An  
Bord  
Pleanála

# Technical Report- Ecology (Addendum to main report) ABP-313586-22

Extension to existing wastewater treatment plant at Dawn Meats Ireland, Painestown, Seneschalstown, Dollardstown, Hayestown-Carnuff Little & Ardmulchan, Navan, Co. Meath

Figure 4.1: Assimilative Capacity Results for the River Boyne at 400 M³/day

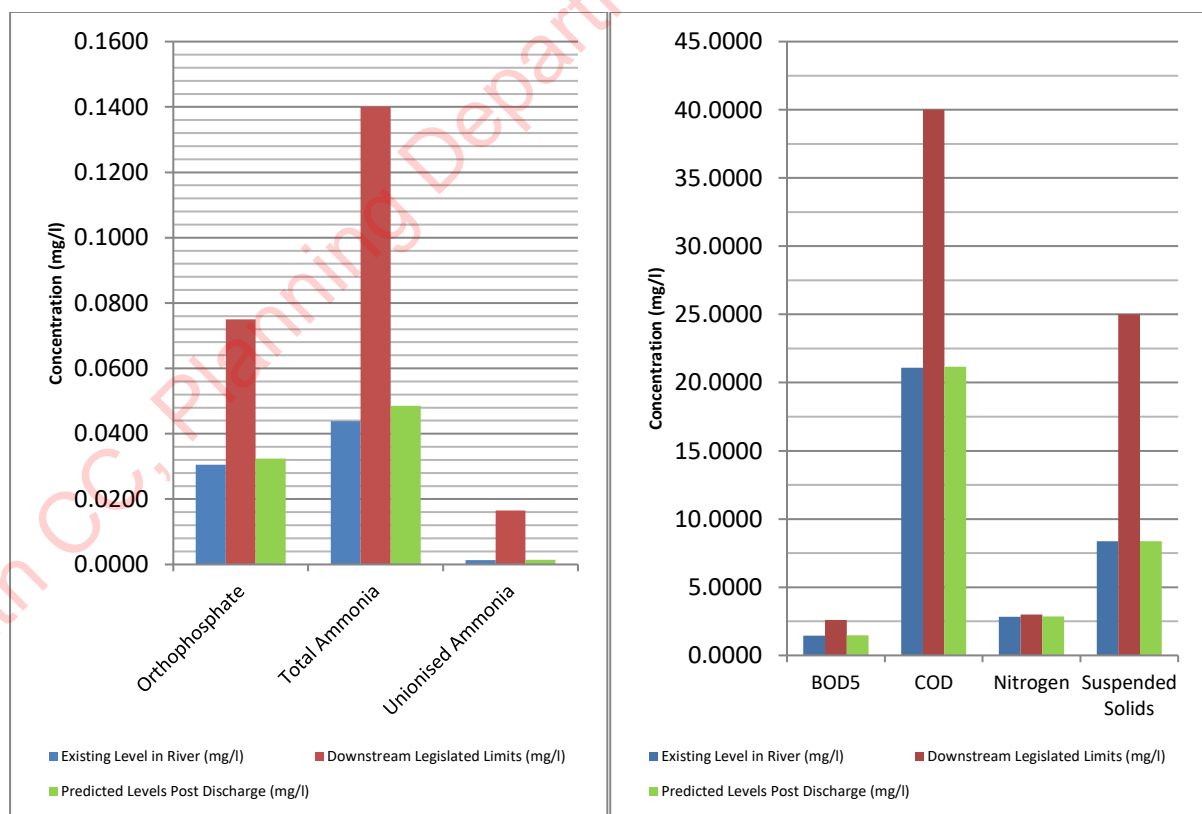
- 1.3.4. The independent review undertaken by Dr Walls, found that the predicted results of the Assimilative Capacity Assessment and Mixing Models were inconclusive. Dr Walls attributes this to data gaps/lacunae regarding the proposed development and its activities, and the lack of representative environmental data relating to the receiving environment at the outfall location and the zone of influence.

- 1.3.5. As the impact assessment of the proposed development is heavily reliant on the outfall levels predicted in the models, the finding that these levels are inconclusive undermines impact predictions for aquatic ecology in particular and introduces scientific doubt to the findings of the NIS.
